Meeting Title: St Matthew's Catholic College – SSD submission review

Date: 13th August 2020

Note: Item references in meeting refer to meeting minutes between TSA and MWRC from 20/07/20.

DRAWING TITLE  
**INTERSECTION UPGRADE PLAN - SHEET 2**

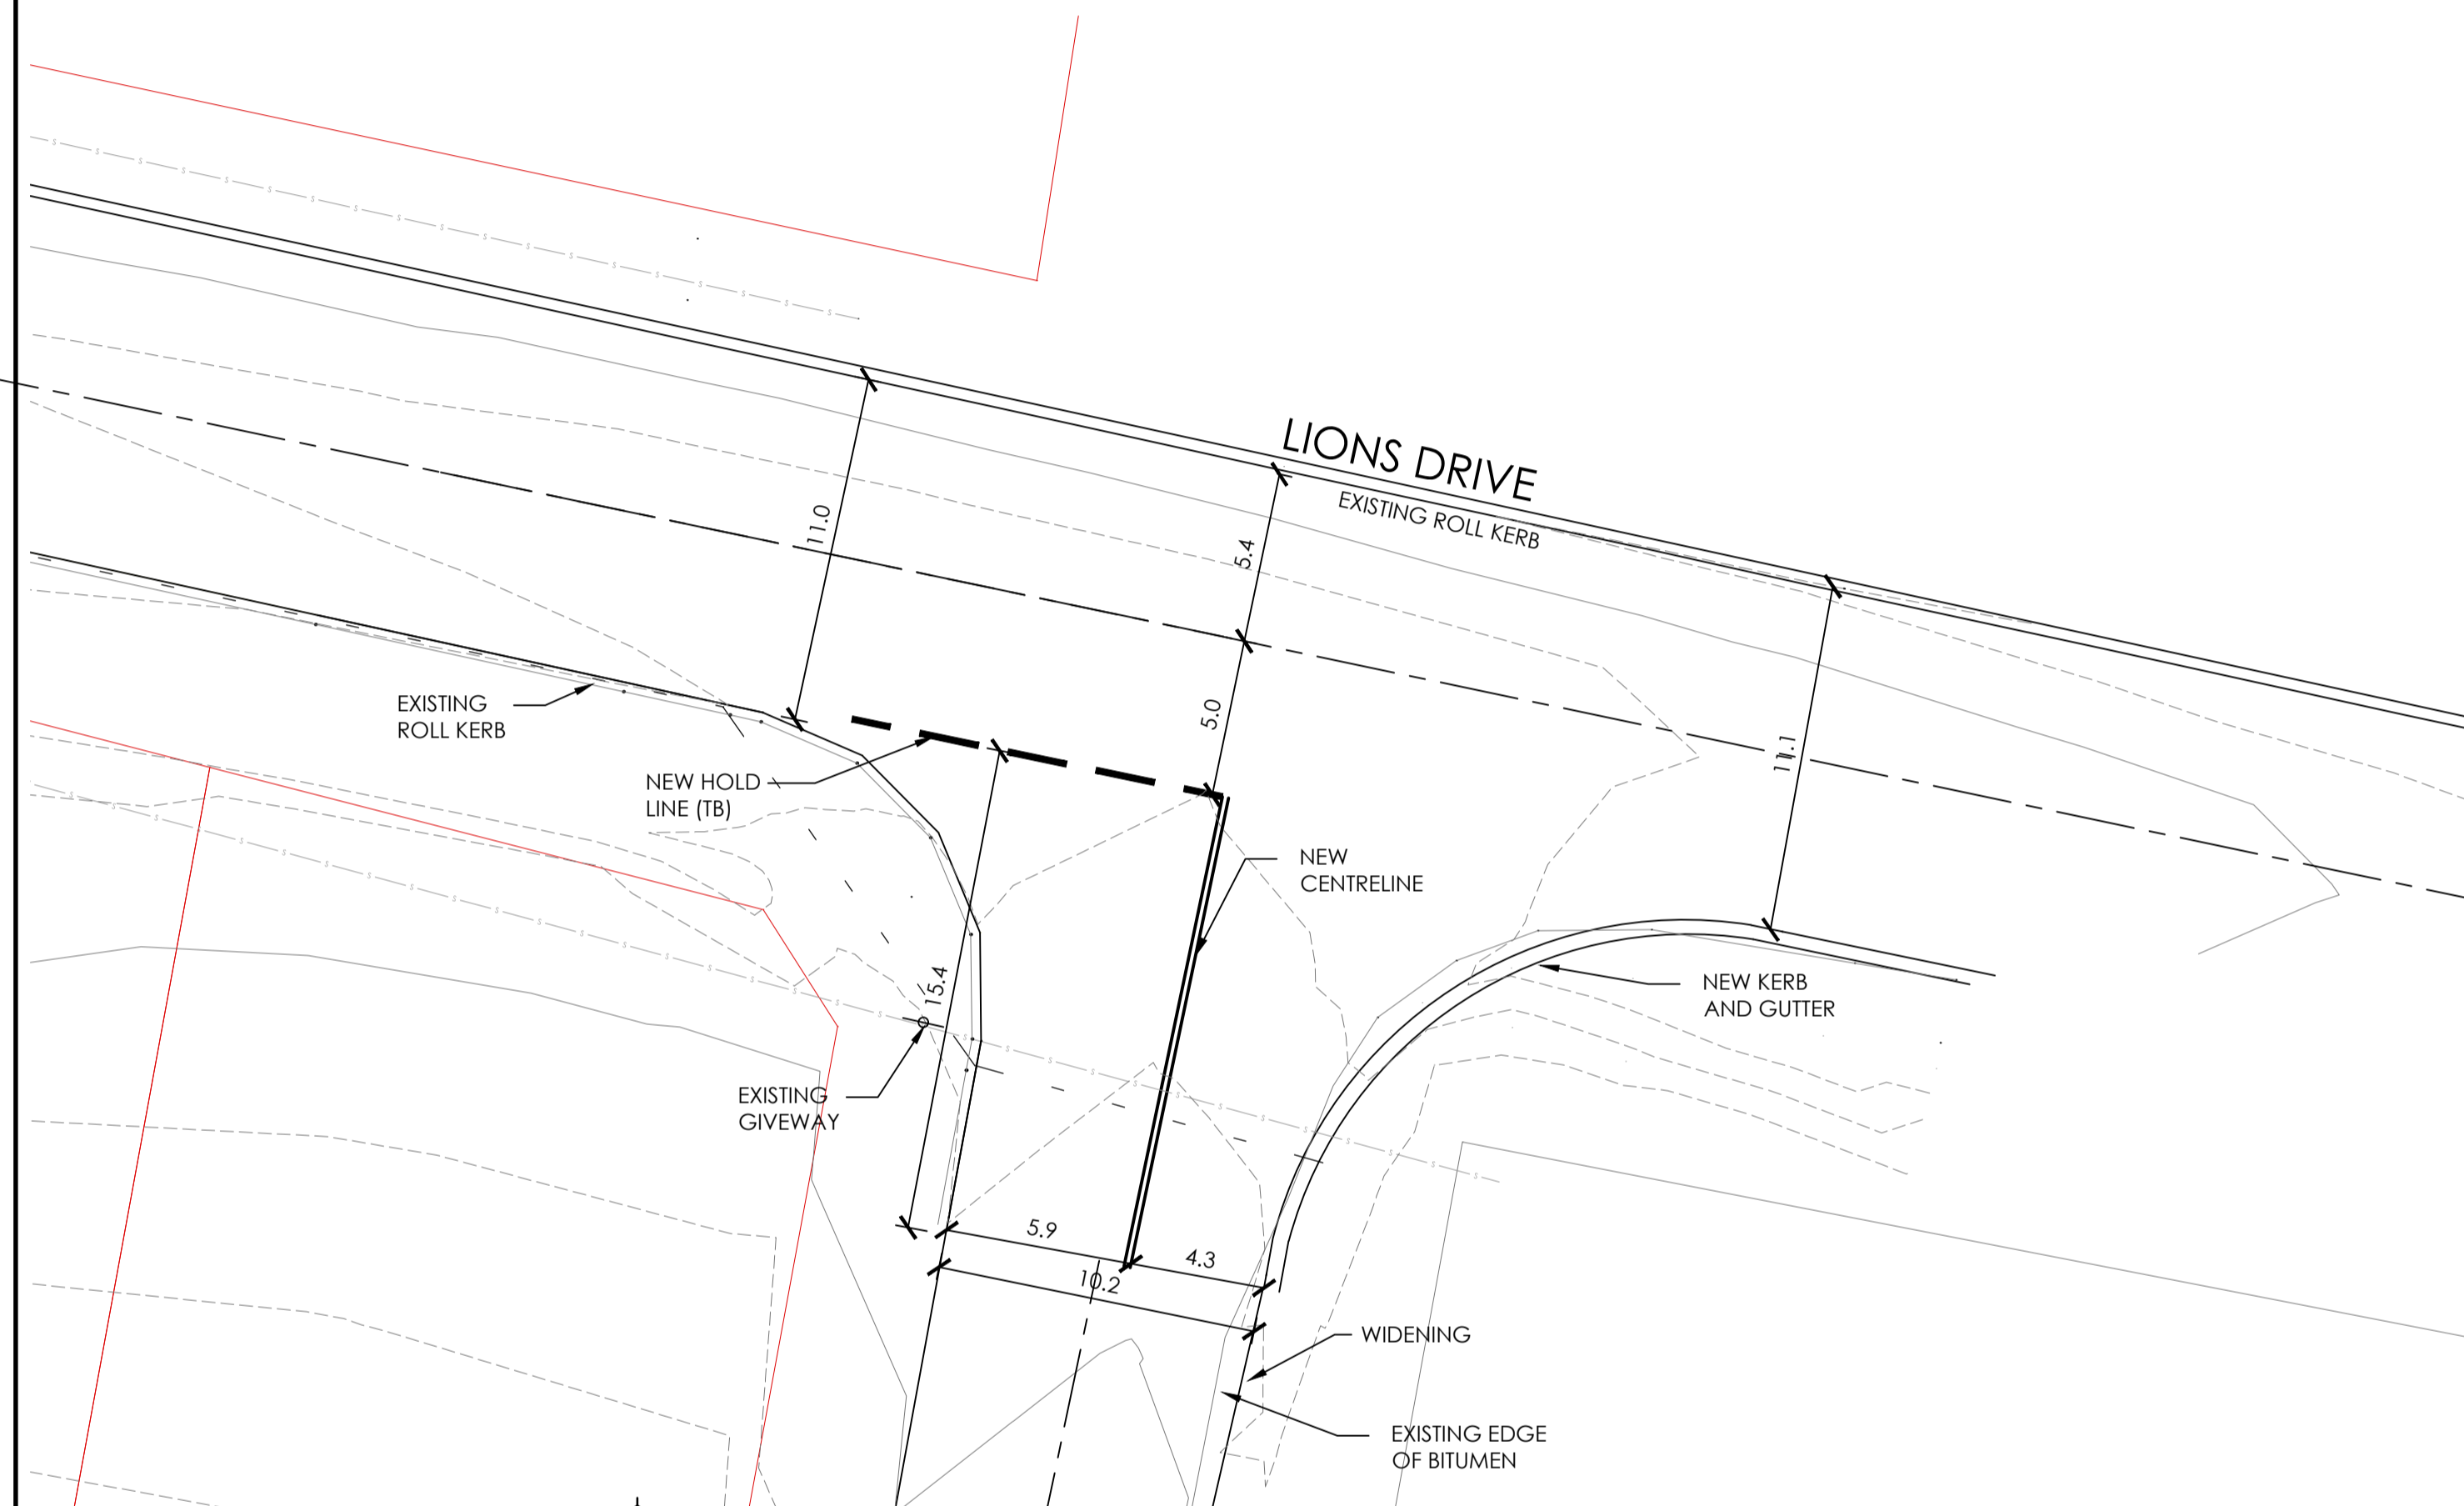
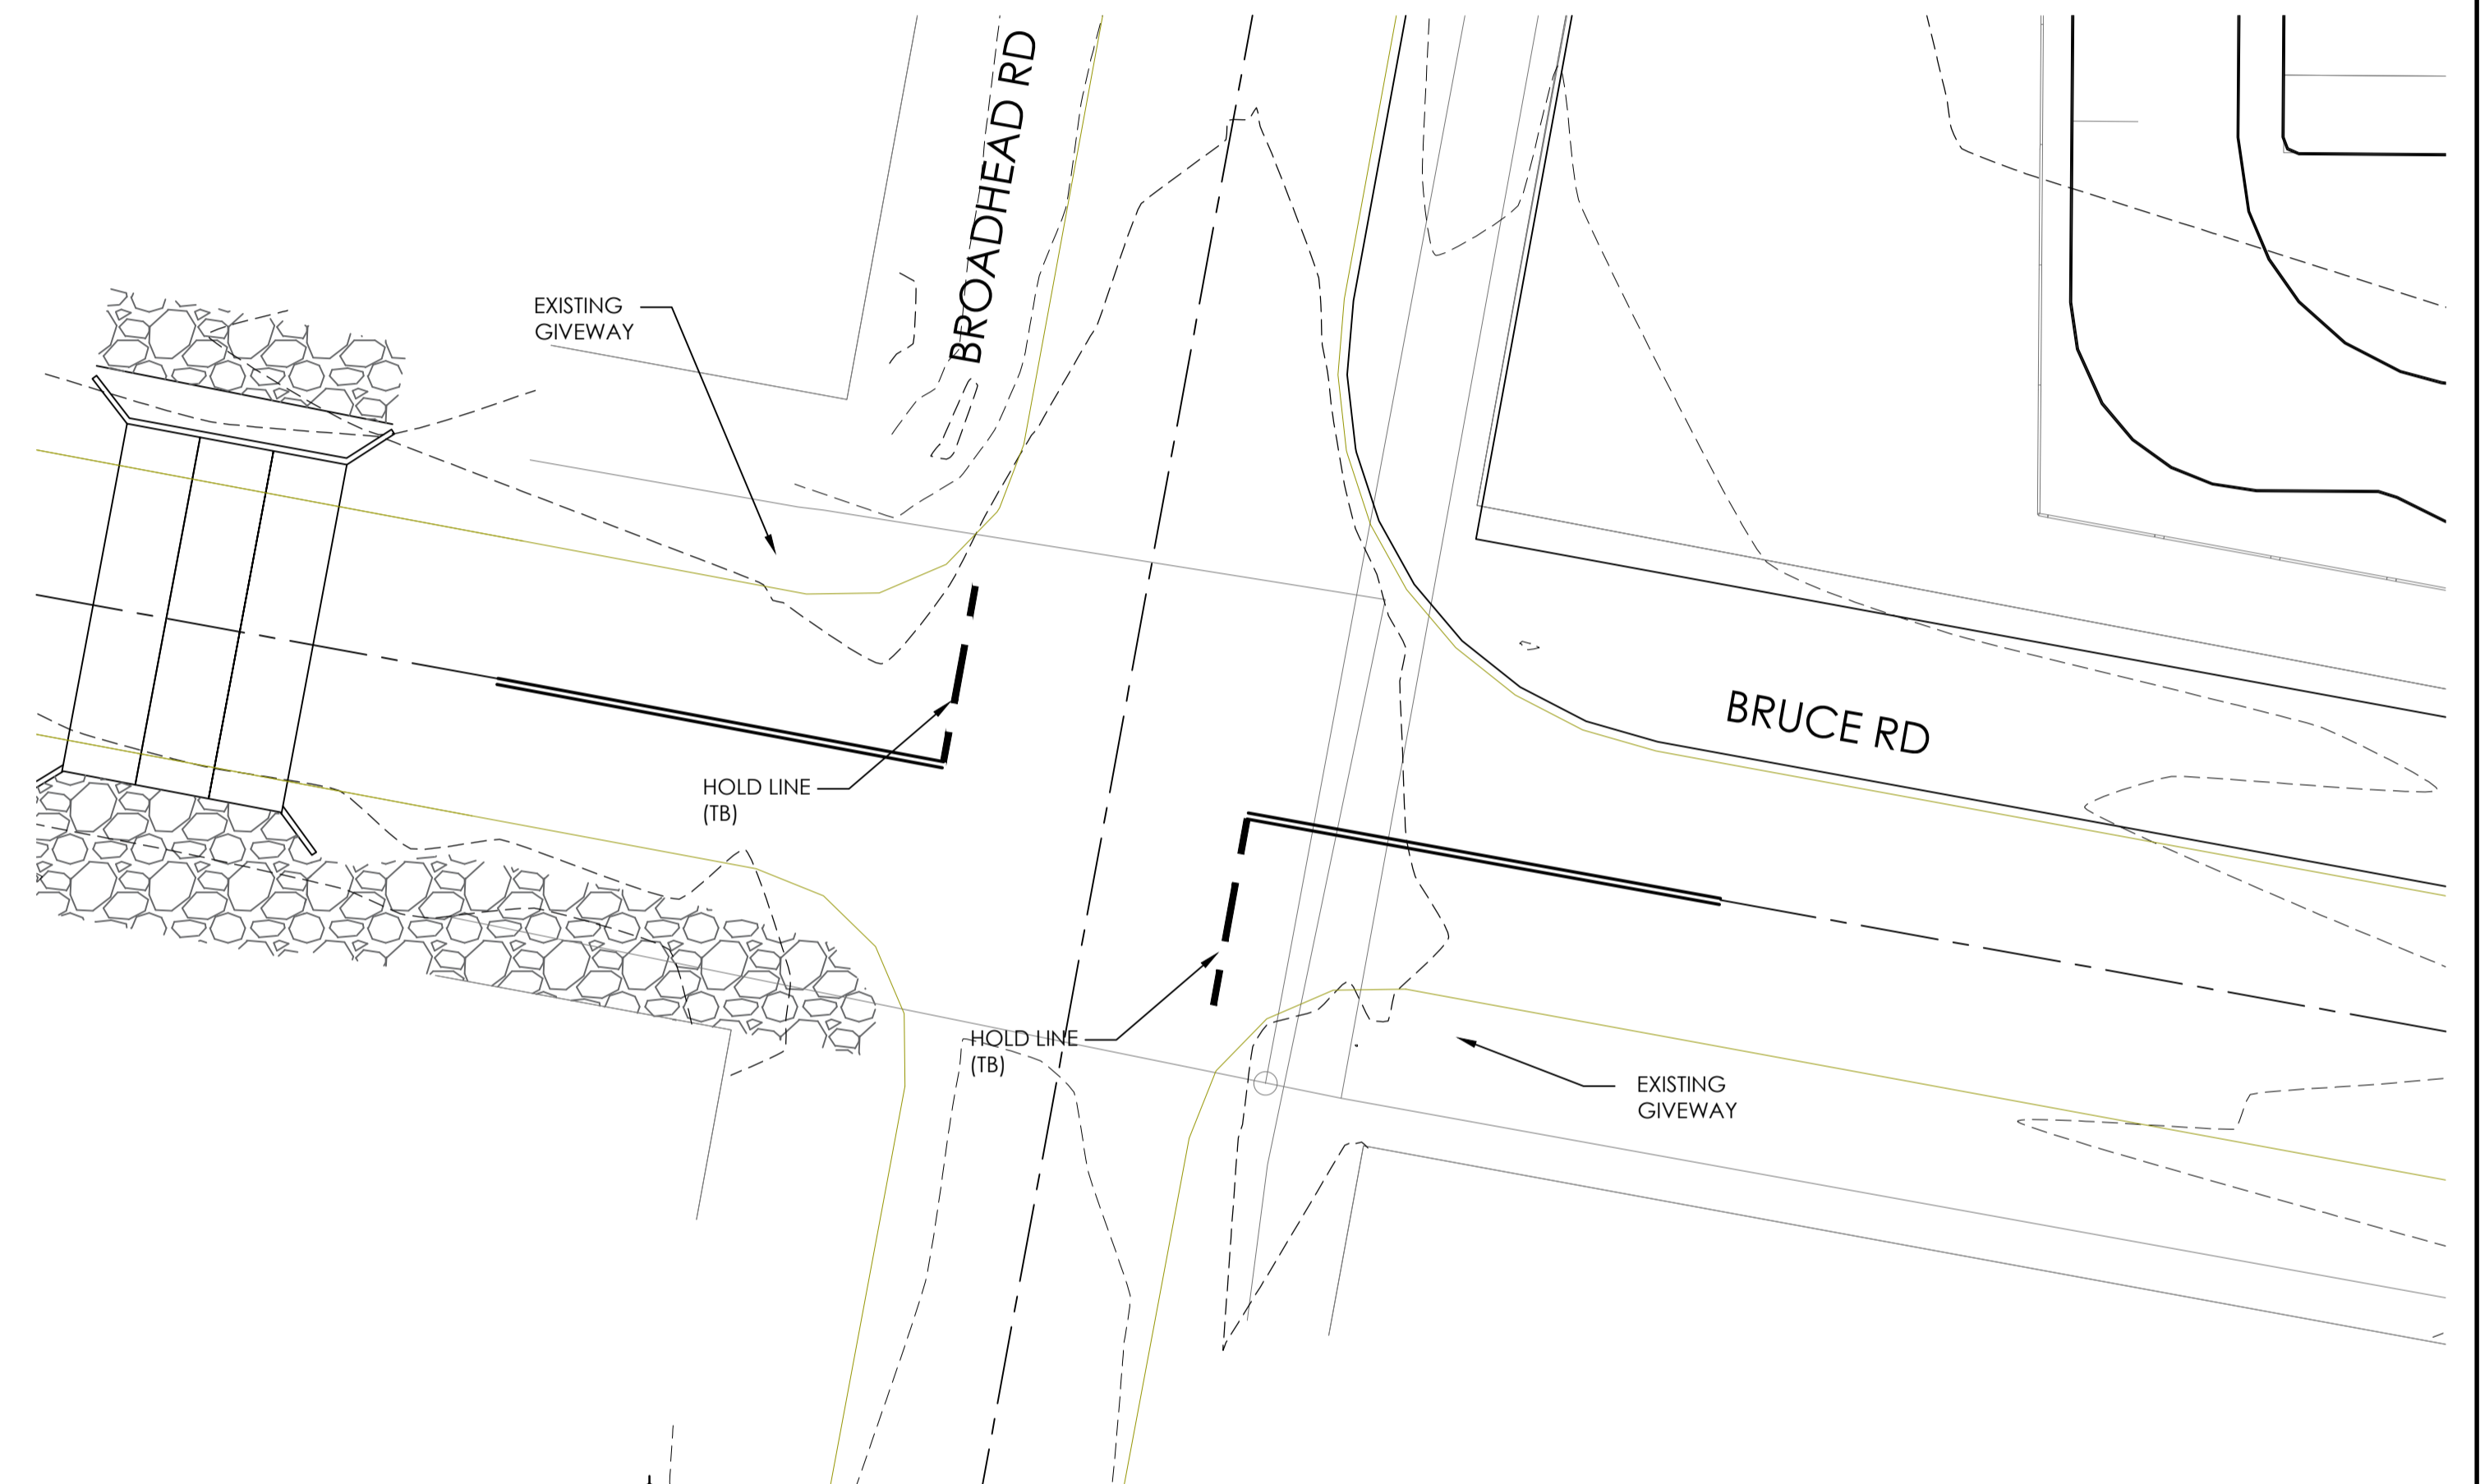
3.	<u>Upgrade of 4 Intersections (item 1.3.5)</u> The previous agreement to the upgrade of the Broadhead Road and Lions Drive along with the Broadhead Road and Bruce Road intersections was noted. All parties agreed that the remaining 2 intersections requested to be upgraded being Lions Drive and Robertson Road along with Bruce Road and Robertson Road intersections would be upgraded, for light traffic only, to service the school. CN to arrange additional studies and reviews to confirm the upgrades required.	Note CN	 21/8/20
